**From:** Parish Clerk Billington and Langho Parish Council  
<parishclerk@billingtonlanghopc.org>  
**Sent:** 04 March 2024 07:12  
**To:** Planning  
**Subject:** 3/2024/0090

Following consultation with the parish council, the following objections were raised:-

Drawing Number
PL/01

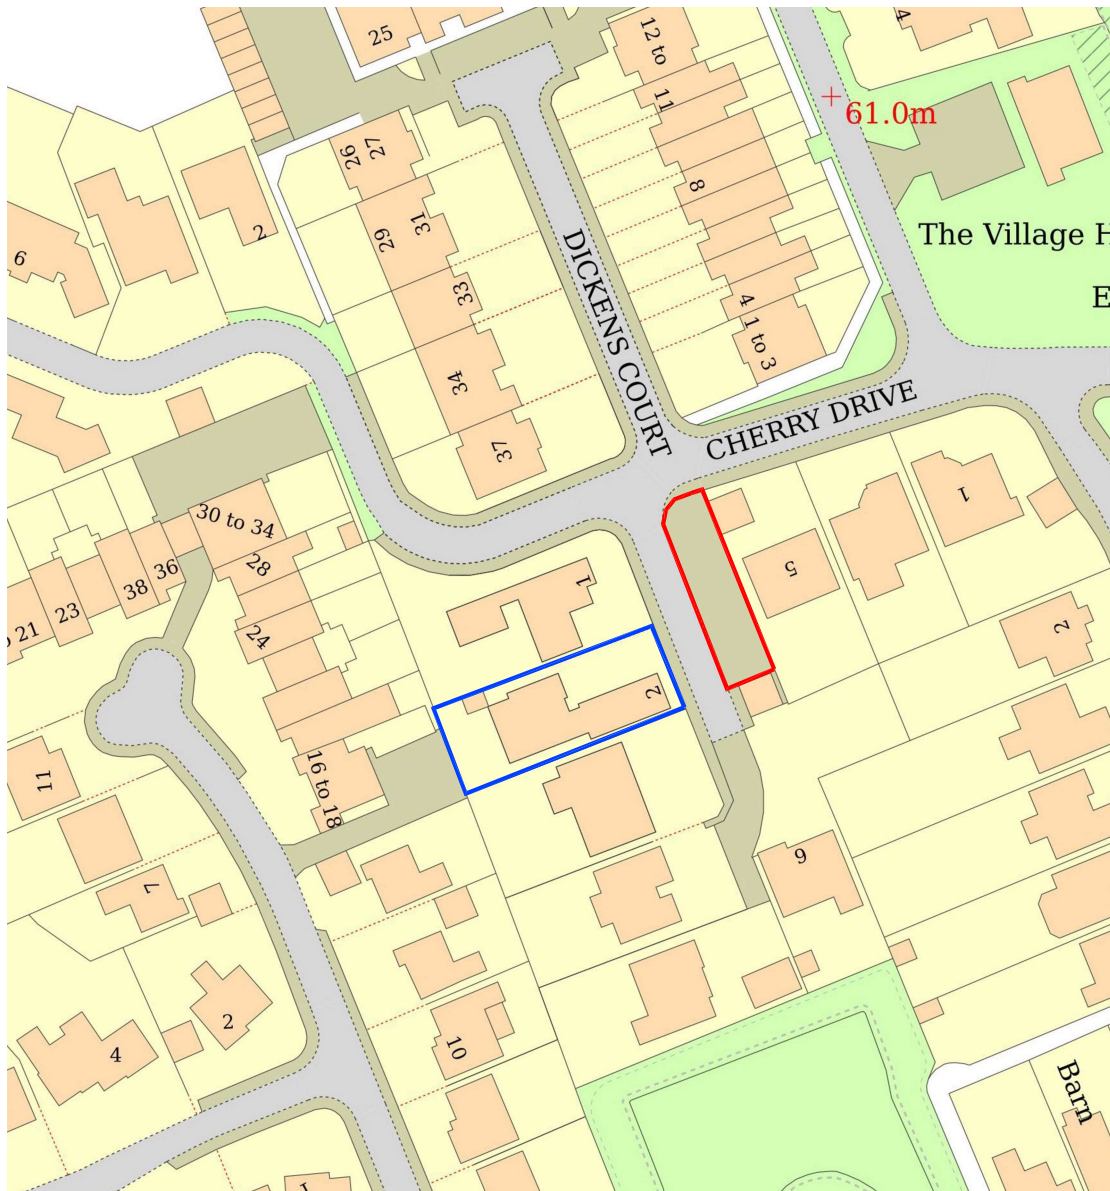
- Like application 3/2022/0725 that has been refused previously, no new houses should be built in the settlement until the new road constructions originally specified for the settlement have been completed. The parish referred to this condition in its objection to that application, which has been sustainably refused by RVBC.
- The proposed house appears to be invading the privacy of the nearest existing house, the nearest windows on the first floor being around 3 metres from their windows. The boundary wall would obstruct any mutual views on the ground floor.
- Rights of light may be obstructed if the proposed building were erected. we suggest this needs technical evaluation by the planners.
- The site is a bit narrow for the large building proposed and no pavement footpath is shown on the plan.
